Consultation Response from KC, Conservation & Design**2023/90488 Land north of, Halifax Road, Hartshead Moor, Cleckheaton, BD19 6PE****Demolition of existing buildings, erection of 9 dwellings and alterations to convert existing barn to 1 dwelling****Date Responded: 15.05.2023****Responding Officer: Sebastian Pickles****Responding Ref:**

HOUSE TYPE D
FLOOR PLANS

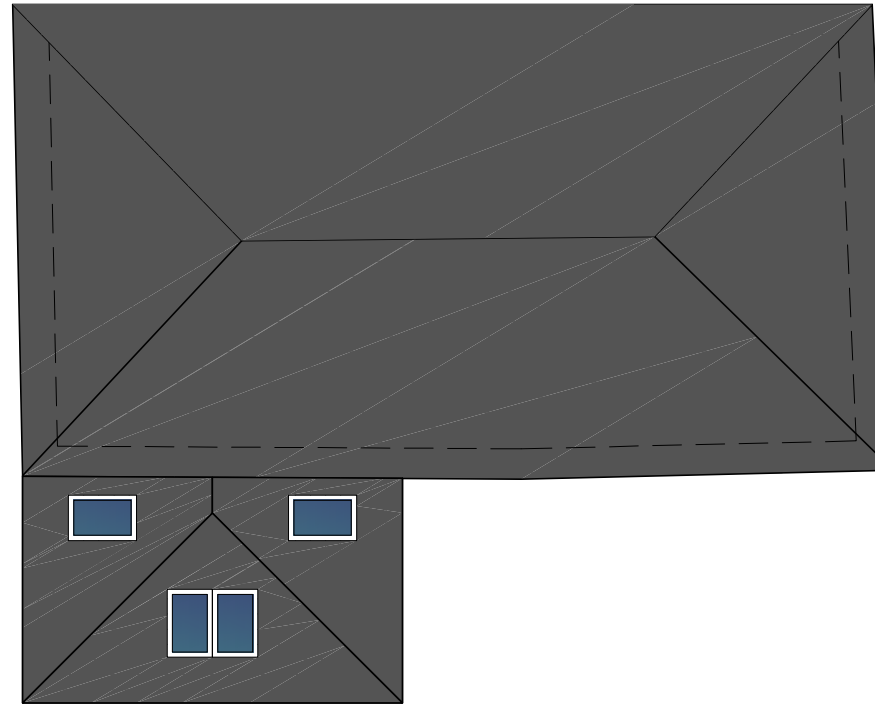
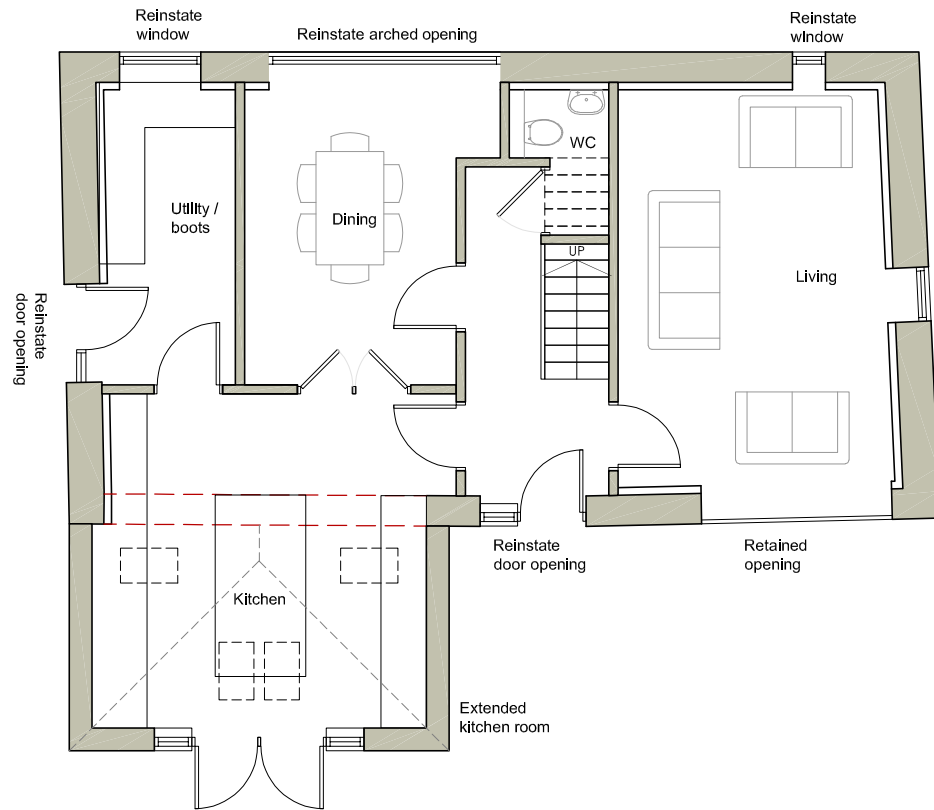
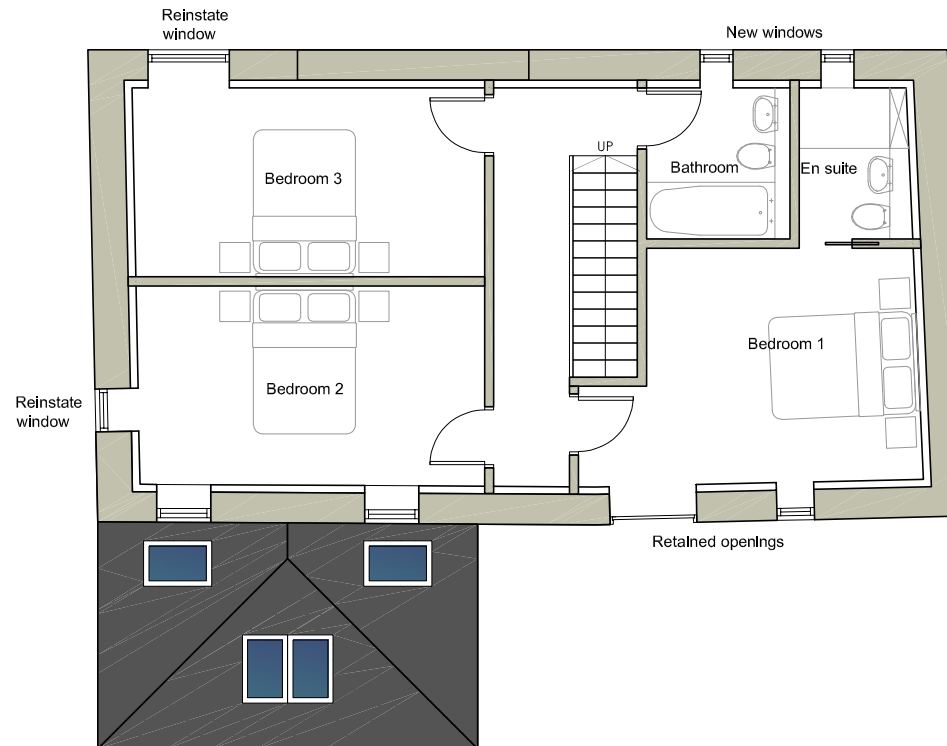
We are entirely supportive of the retention and conversion of the barn. We are however not convinced by the detail of how this is to be achieved. The main elevation facing Halifax Road is to remain unaltered, save the first-floor door is to be infilled. We understand the rationale behind this however, we do consider this is a missed opportunity. It would be an enhancement for the main arch to be opened up and would additionally provide additional light.

To the rear, the existing large extension is to be removed. The plans show that the ground floor wall is to be entirely removed and a full-length extension added. To the upper floor, the existing openings on the rear elevation are to be infilled and then 3 new openings are to be created.

We do not support the proposals for the barn, which are entirely out of character with the building and do not respect its historic vernacular. We are supportive, as set out of bringing the building into a better use and there is the opportunity to enhance the building, however the proposals as presented fail to do this. The proposals create a highly urbanised and standardised feel to the building. We are not opposed to an extension to the barn. The extension needs to be more subservient to, ensuring it is set in from either side and works in harmony with the building. We encourage that less of the ground floor wall is removed. The extension does have a large amount of glazing, which we are not opposed to, and this could be taken further.

Equally we consider the existing openings at first floor should be retained and any new openings proposed should be irregular and of a nonstandard size to better reflect the character of the building.

PROPOSED SITE PLAN
SCALE 1:200 @ A1

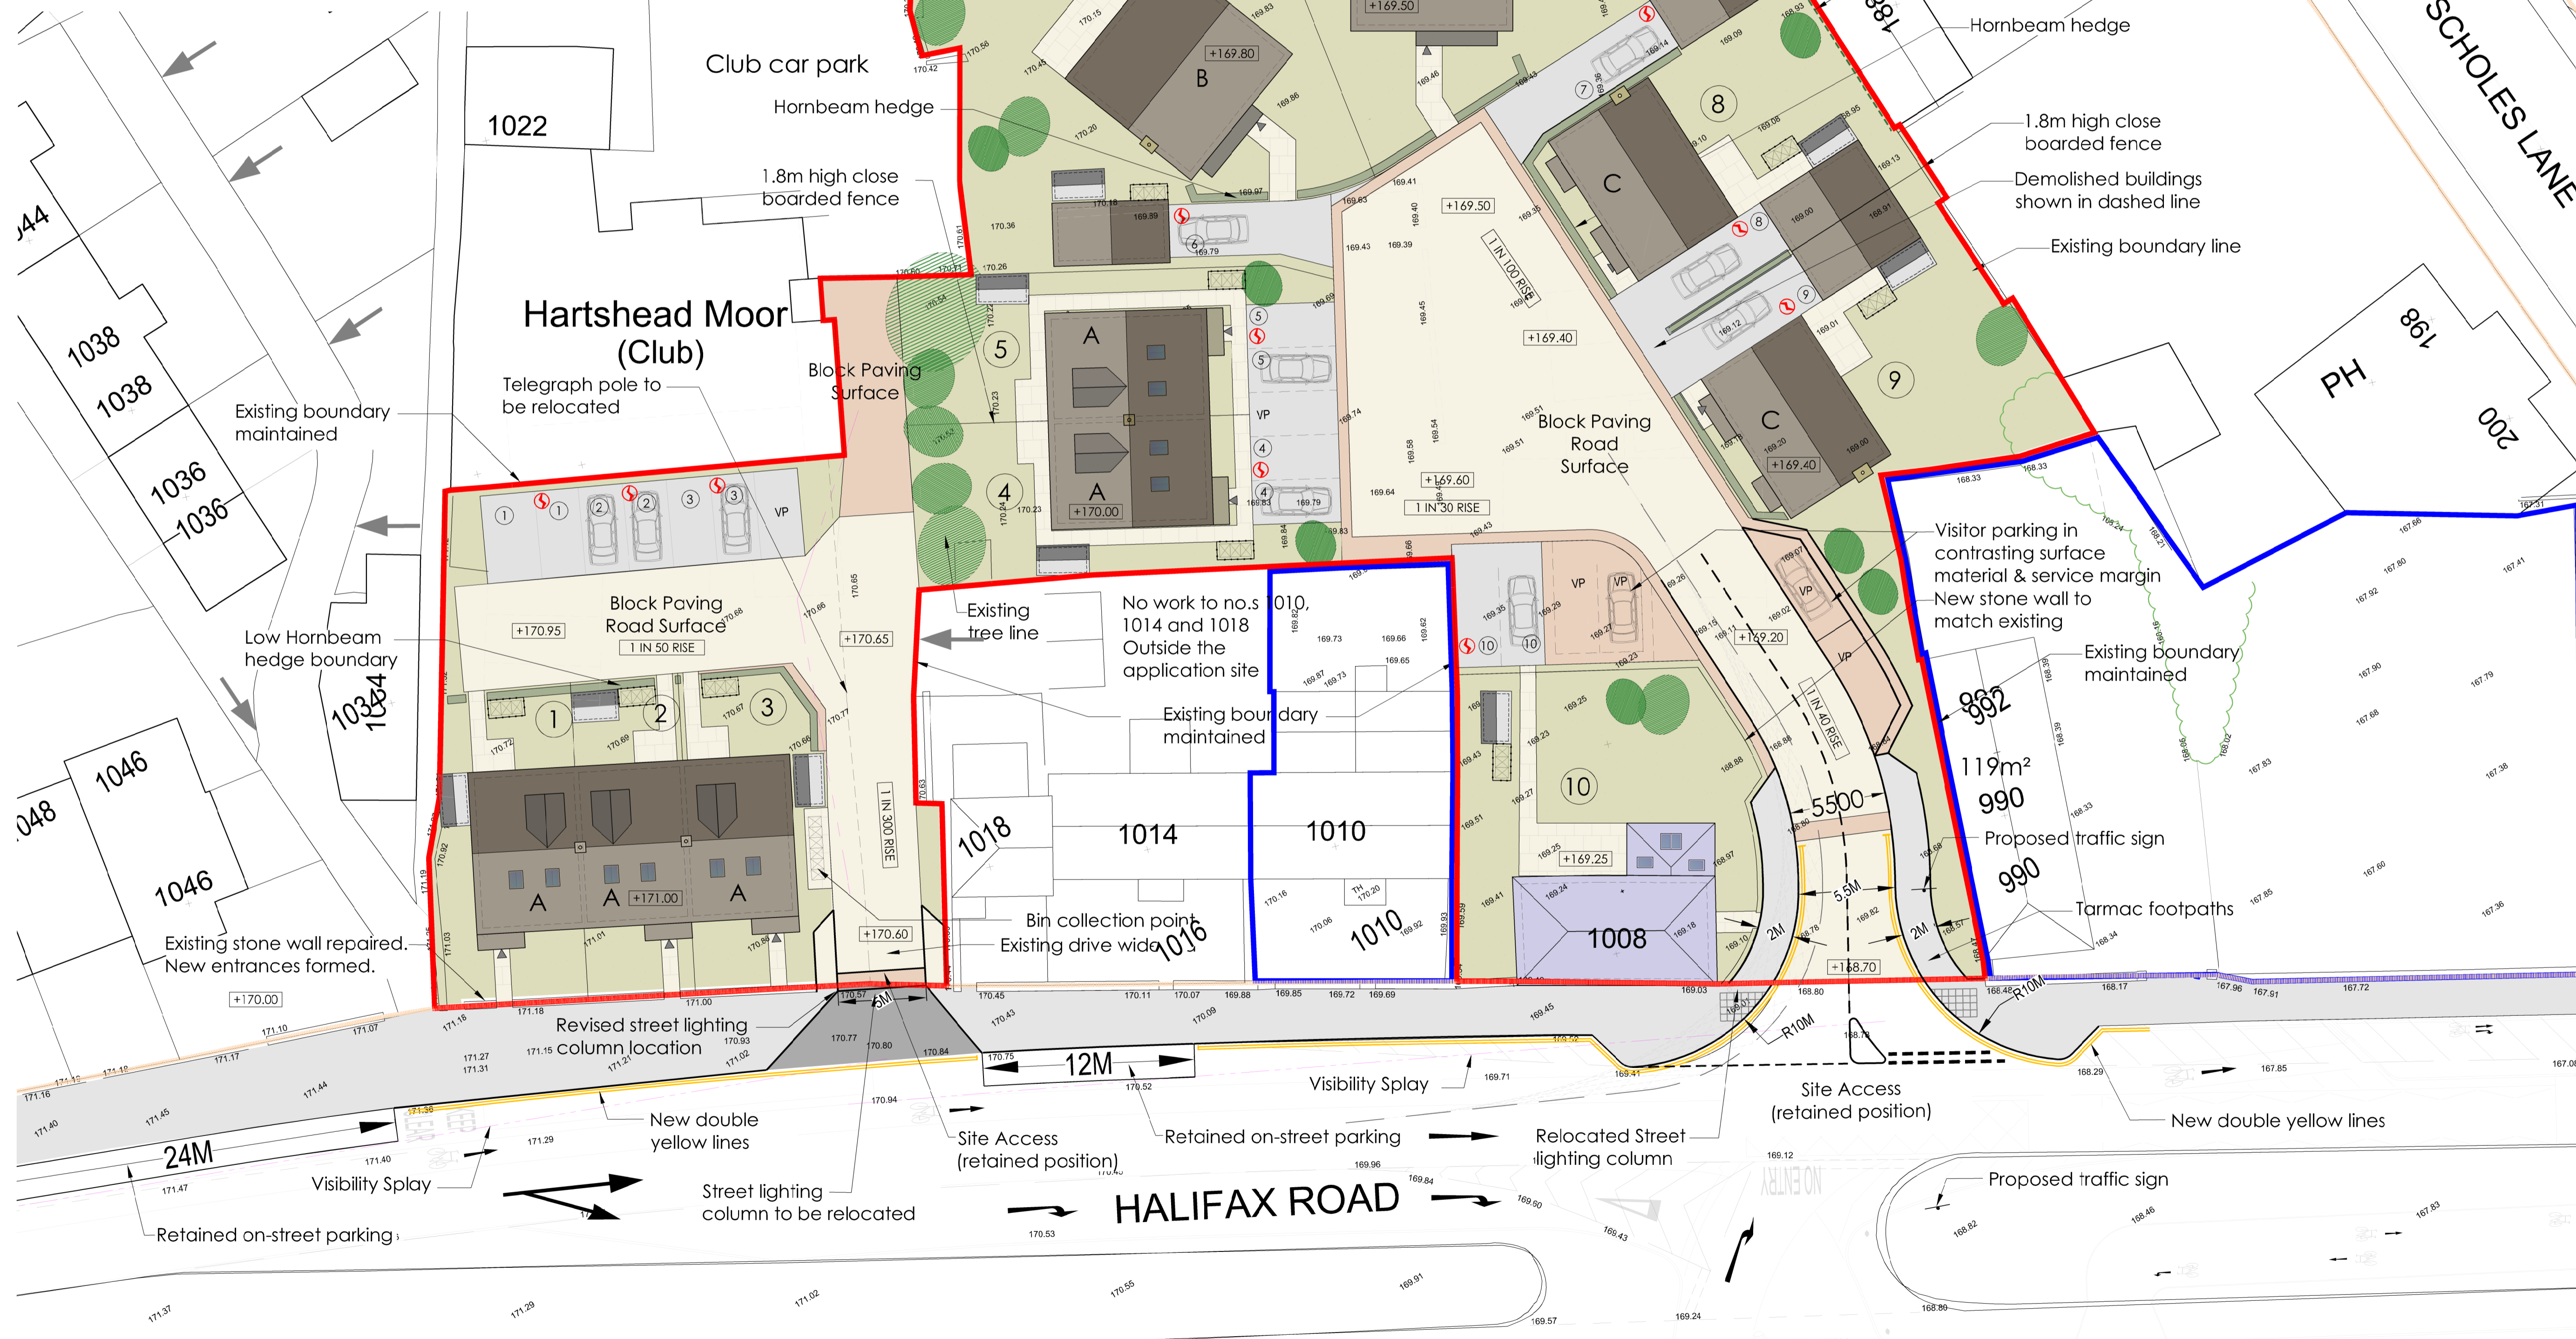
There does appear to be some ambiguity on the plans. Looking at the individual plans they show details such as projecting bays, porches and dormer windows on some of the buildings, however this is not reflected on the proposed site plan. The site plan needs to be amended to fully and accurately reflect the detail of the proposed units.

We are not convinced by the introduction of the detached garages. The addition of the garages adds further built form and interrupts the remaining sense of openness within the site and views looking into the site from along Scholes Lane. We consider that the garages should be omitted from the plans.

Under the pre-application comments we raised concerns regarding development to the north and centre of the site, which is now covered by units 4,5, 6 and 7. We still have concerns in this respect. While there has been changes in the number of units, this does see a high number of units proposed which will erode the historic open/ green space, which has had a long-standing contribution to the area. It might be that a reduction of the number of dwellings in these locations could reduce the impact. It would however be subject to further assessment.
